Application Ref:	3/2020/0594	 Ribble Valley Borough Council www.ribblevalley.gov.uk
Date Inspected:	03/11/2020	
Officer:	RB	
DELEGATED ITEM FILE REPORT:		APPROVAL

Development Description:	First Floor Extension over garage and extension of existing decking to rear of dwelling.
Site Address/Location:	20 George Lane, Read, BB12 7RH

EXISTING & PROPOSED
BLOCK PLAN
20 GEORGE LANE
READ
SCALE 1:200

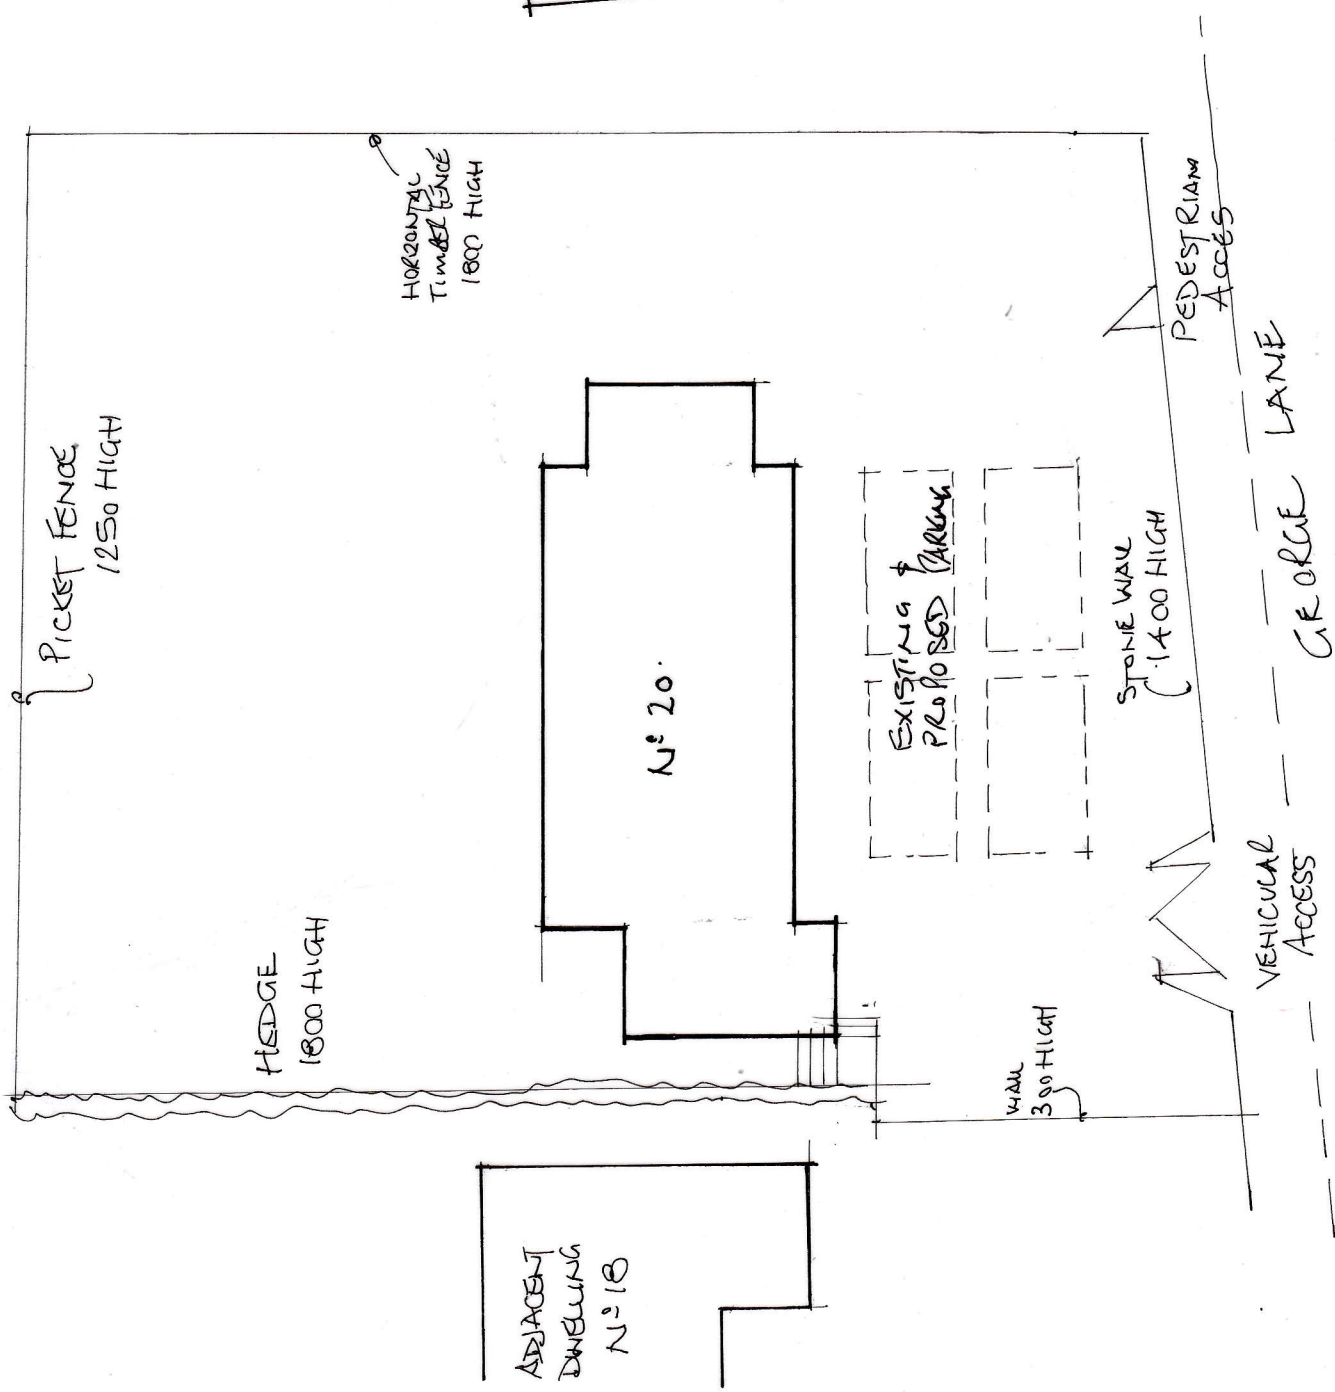
The neighbour to the south no 18 does also have a boundary hedge partially screening the site but the proposed decking could potentially result in the overlooking of this neighbour. Therefore, it was requested that the plans be revised to include the erection of an obscurely glazed privacy screen. Subsequently plans were received providing the above.

The proposed extension will be erected over an existing flat roof garage therefore the width of the extension is considered acceptable. The development has been amended to reduce the ridge down by approximately 0.2m to the front so that the extension remains subservient to the main dwelling. As well as the above the development will be constructed in matching materials to the main house. Therefore, it is considered that the extension will remain subservient to the main dwelling and will have minimal impact on the visual amenity of the area.
